KITTITAS COUNTY

MEMORANDUM

TO: Dusty Pilkington, CDS
FROM: Kelly Bacon, Engineer Technician I *KB*
DATE: July 15, 2016
SUBJECT: Bailey BL-16-00009

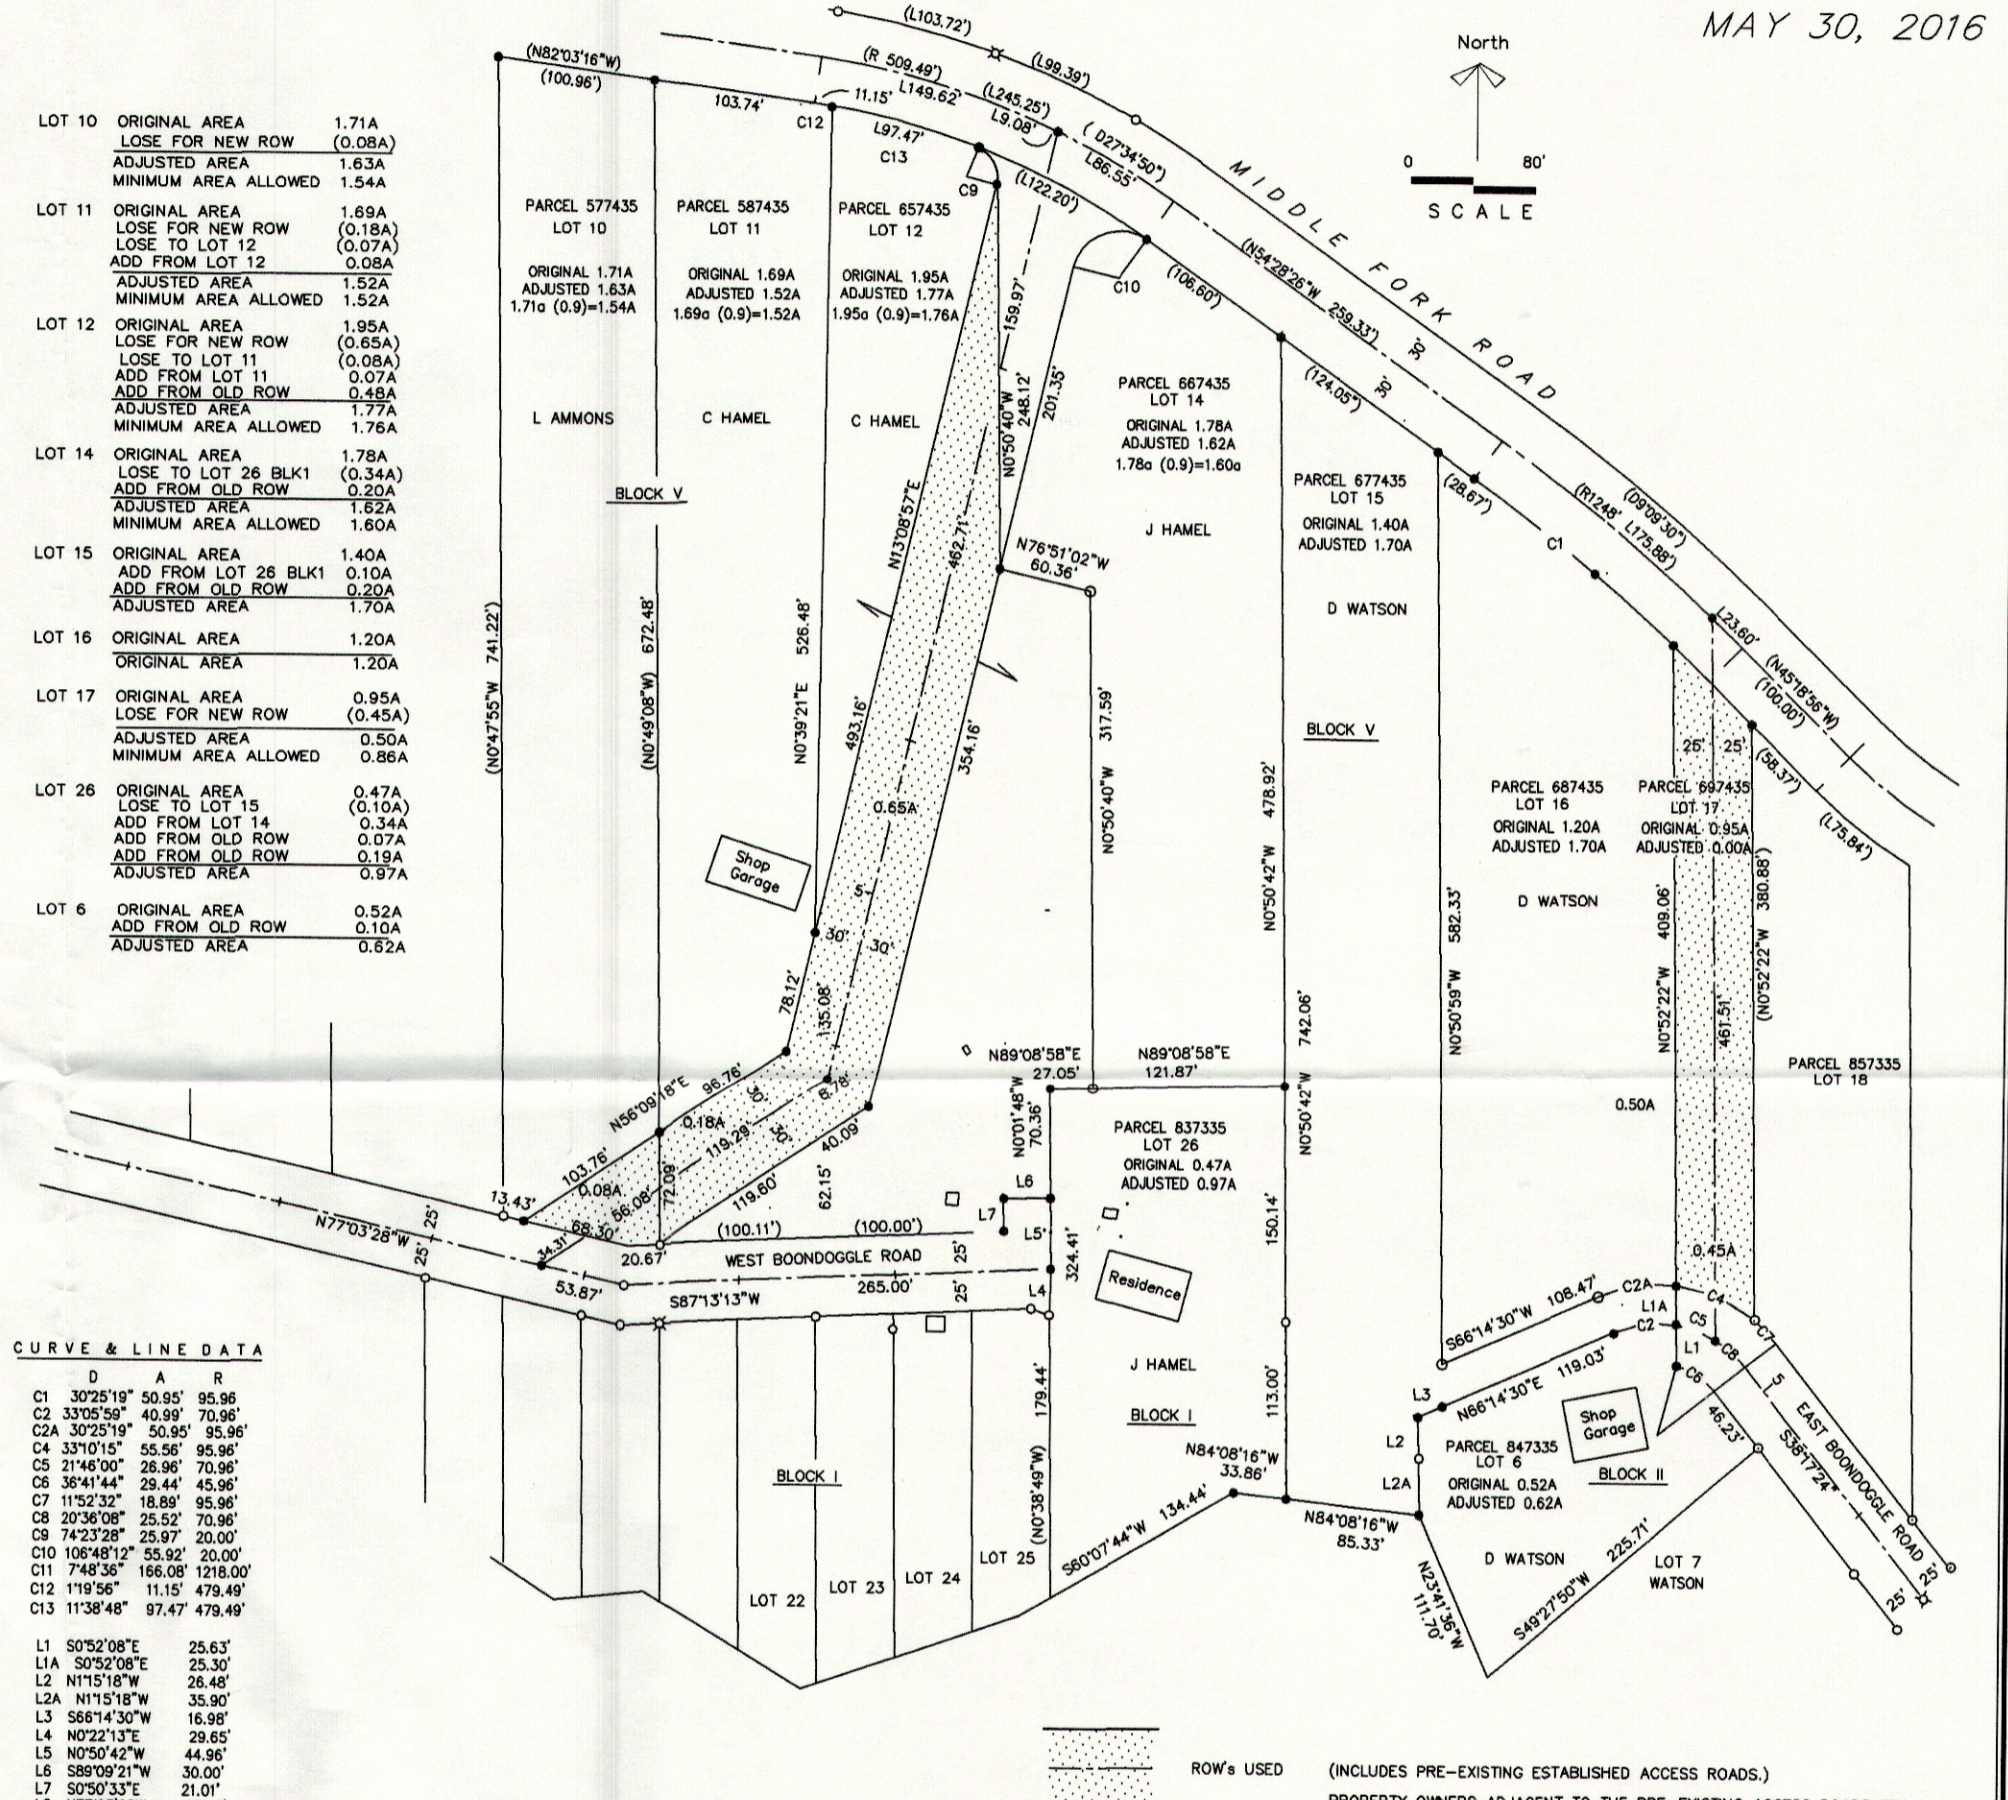
- A. The private road easements need to be a minimum of 60' wide.
- B. A culdesac will need to be shown on the face of the BLA for West Boondoggle Road where it ends at lot 25.
